Albuquerque
Metropolitan
Arroyo
Flood
Control
Authority

November 7, 1996

RE: Praxair Nitrogen Plant, map B-18, plans engineer stamp dated 10-29-96

AMAFCA has reviewed the preliminary construction plans for the referenced project and offers the following comments:

CHANNEL TIE-IN DETAIL
C3

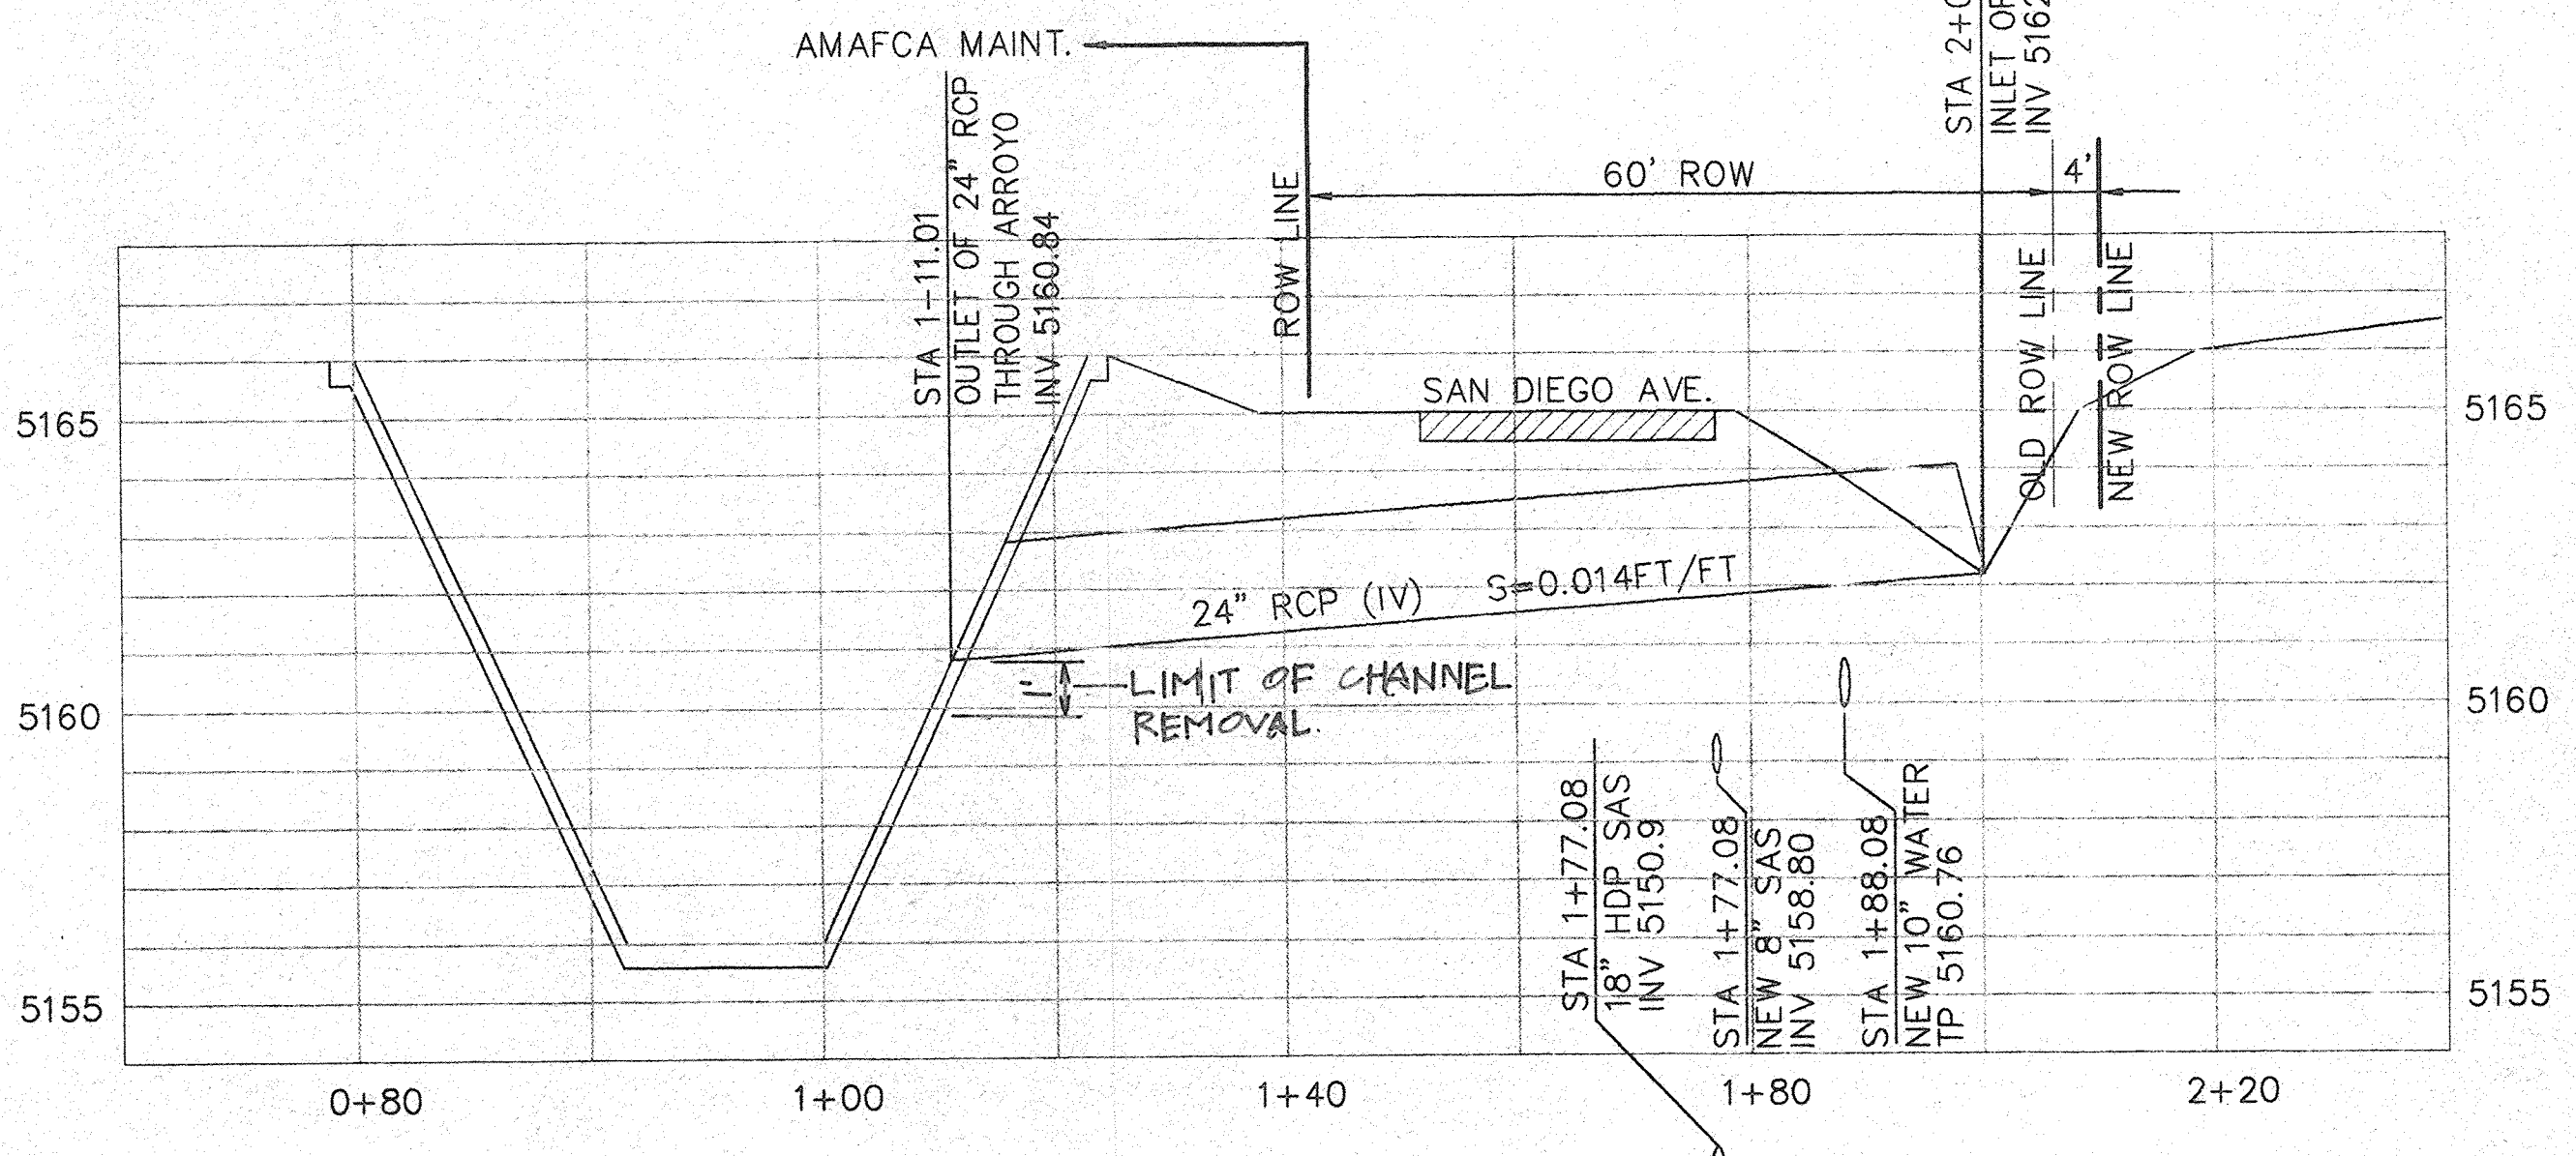
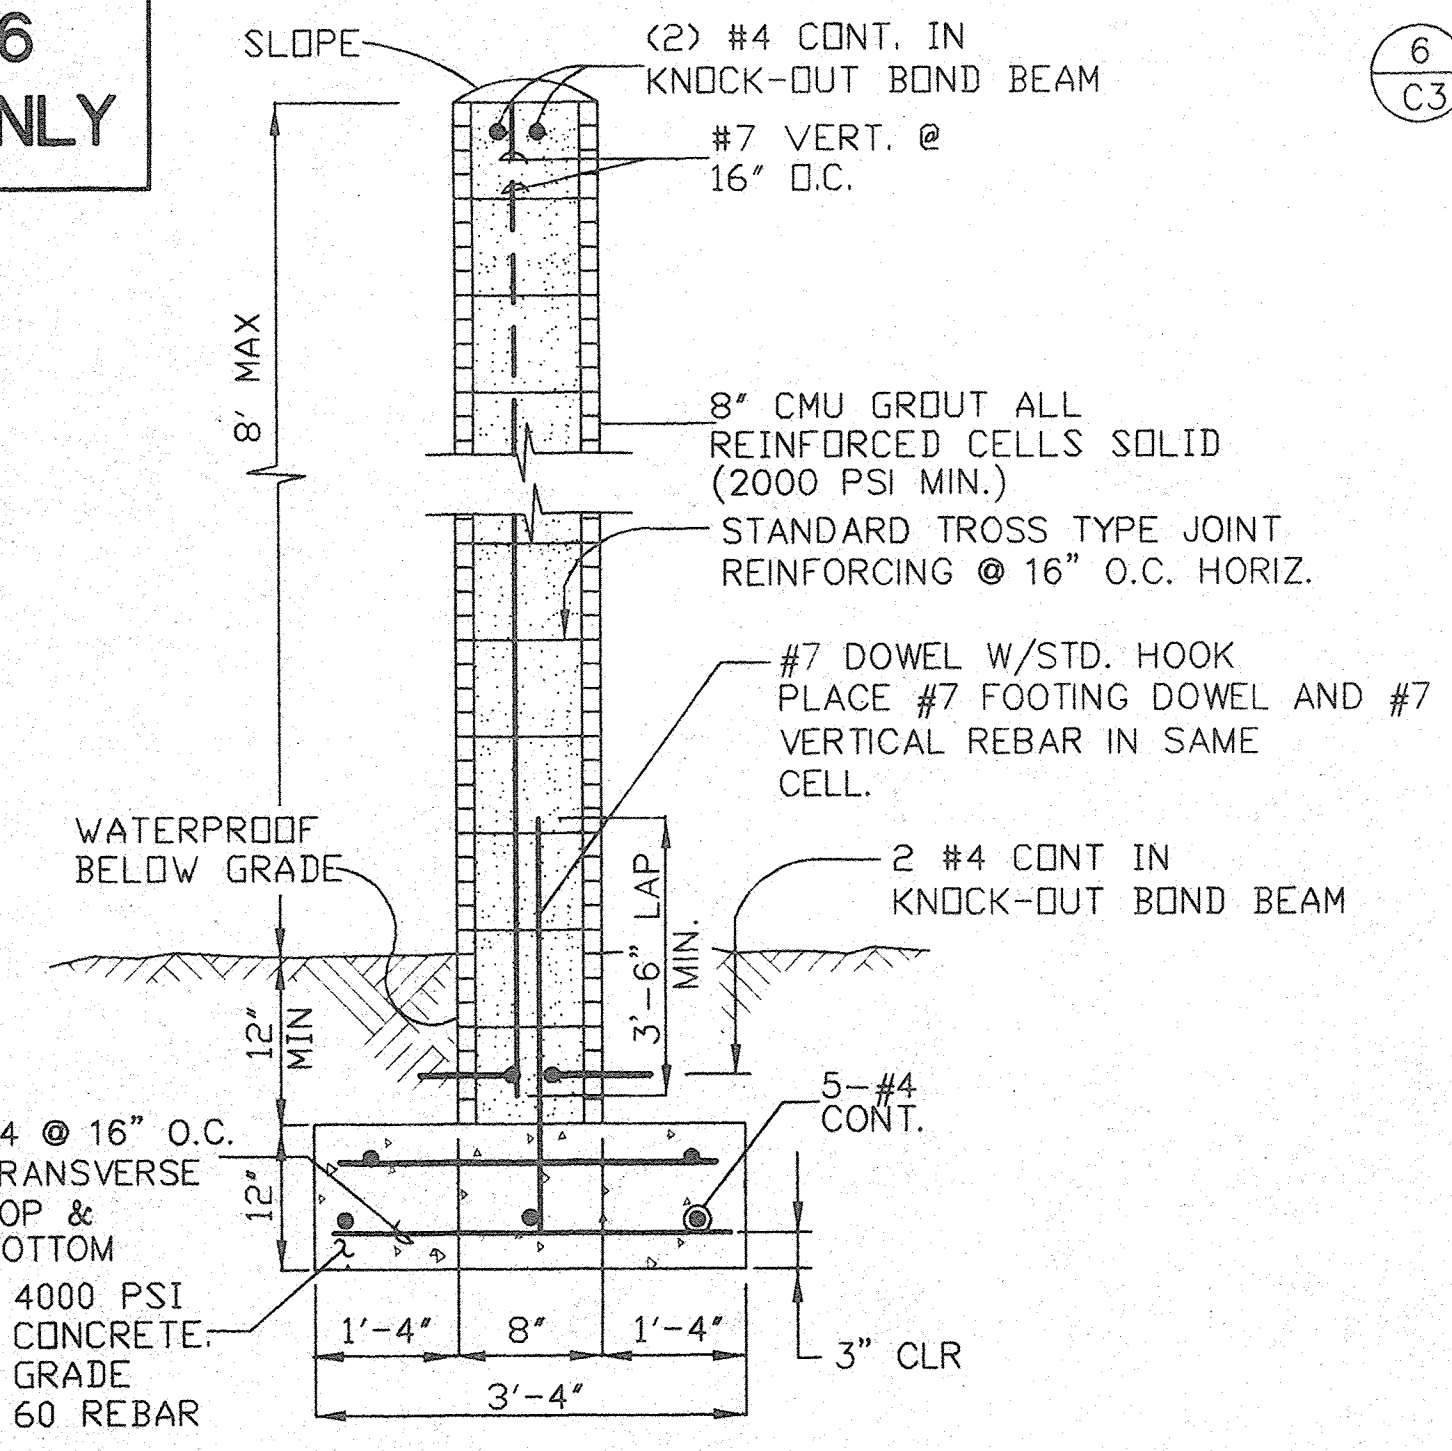
1. How will the west portion of the site drain? Why not locate the outfall (or another outfall) at the west end?
2. The detail for a channel penetration is incorrect. This detail is for a small diameter ductile iron pipe. I have attached a standard detail that you can use. *(Will need to be modified for your alignment, etc.)*
